Your Ref: 23/00978/FUL
Our Ref: DWH/NA/A023/243

Project address: 17 Birley Street, Blackpool

We enclose a Variation of Condition application in relation to the above address. This application is to sub divide the windows on the 1st and 2nd floors of the front elevation and introduce an additional set of doors to the ground floor front elevation.

SIDE ELEVATION

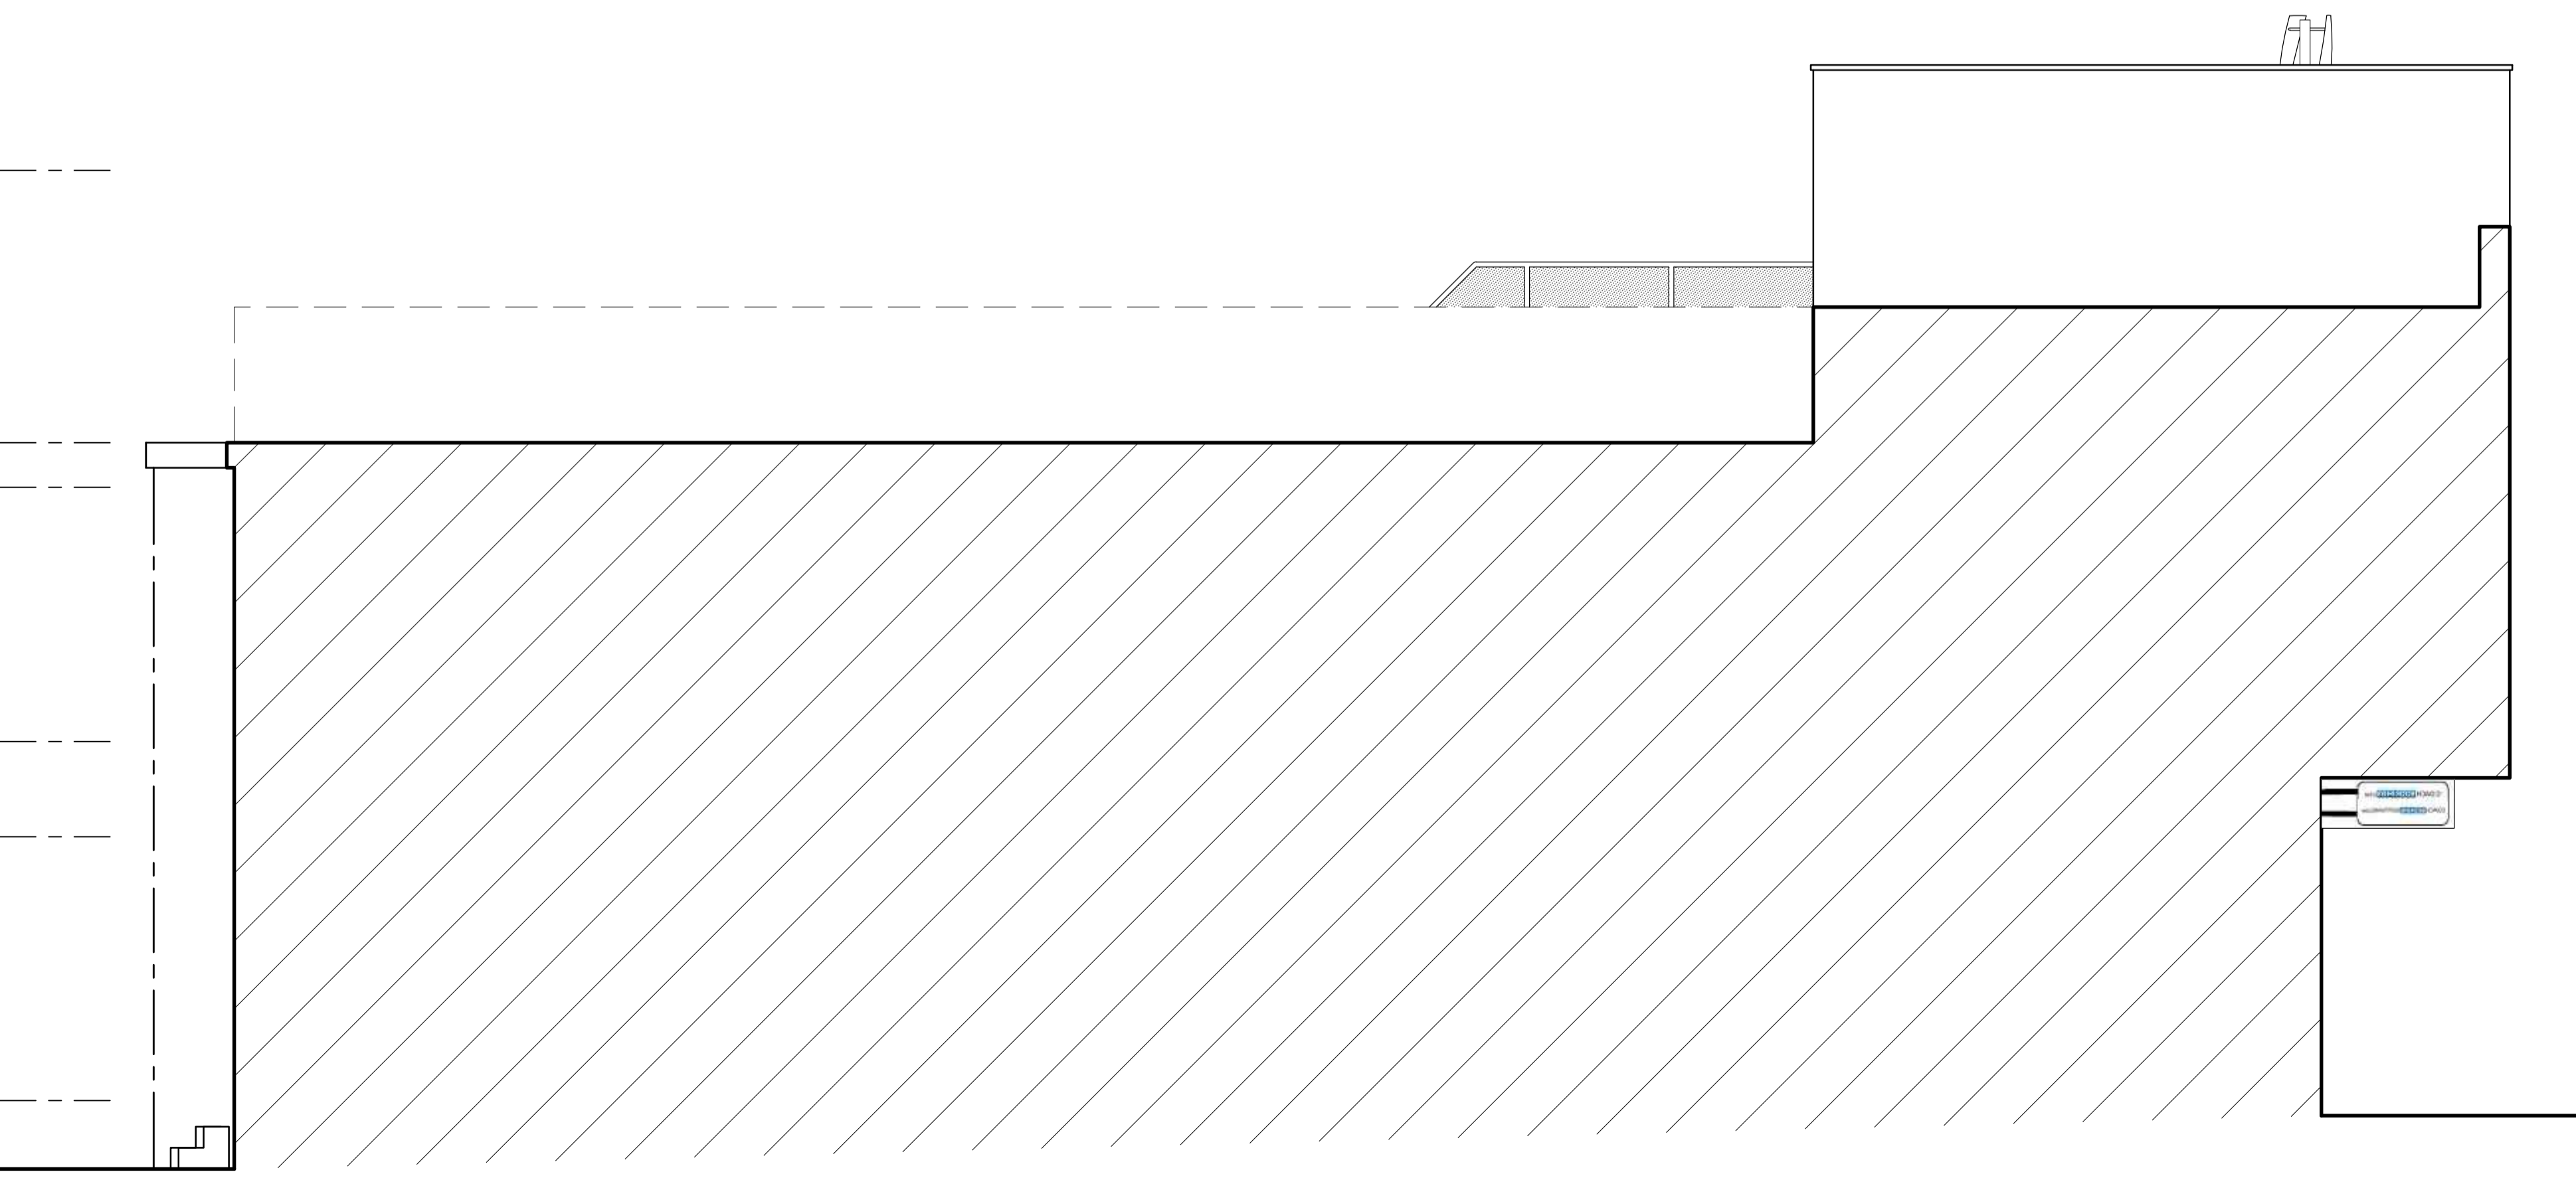
The replacement windows have been carefully designed to maintain the traditional aesthetics of the building, ensuring they blend in with the existing architecture. These proposed windows will also be more user-friendly.

The proposed installation of additional doors to the entrance of the building is to improve security and prevent unauthorised access during non-business hours. This proposal will prevent the ongoing issues of homeless individuals using the vestibule overnight, which can be intimidating and potentially dangerous for staff arriving to work.

As the building is located in a Conservation Area, planning policy will not allow the addition of shutters. However, installing an extra set of doors will ensure that the vestibule will be inaccessible to homeless individuals during non-business hours, ensuring the safety and peace of mind of the staff and passersby. The added security will also protect the building and its contents from further vandalism or theft. Additionally, double entrance doors can help regulate temperature within the retail space by reducing drafts and air exchange. This can prevent cold air from entering during the winter months and hot air during the summer, minimizing the need for heating or cooling systems to work harder to maintain desired temperatures.
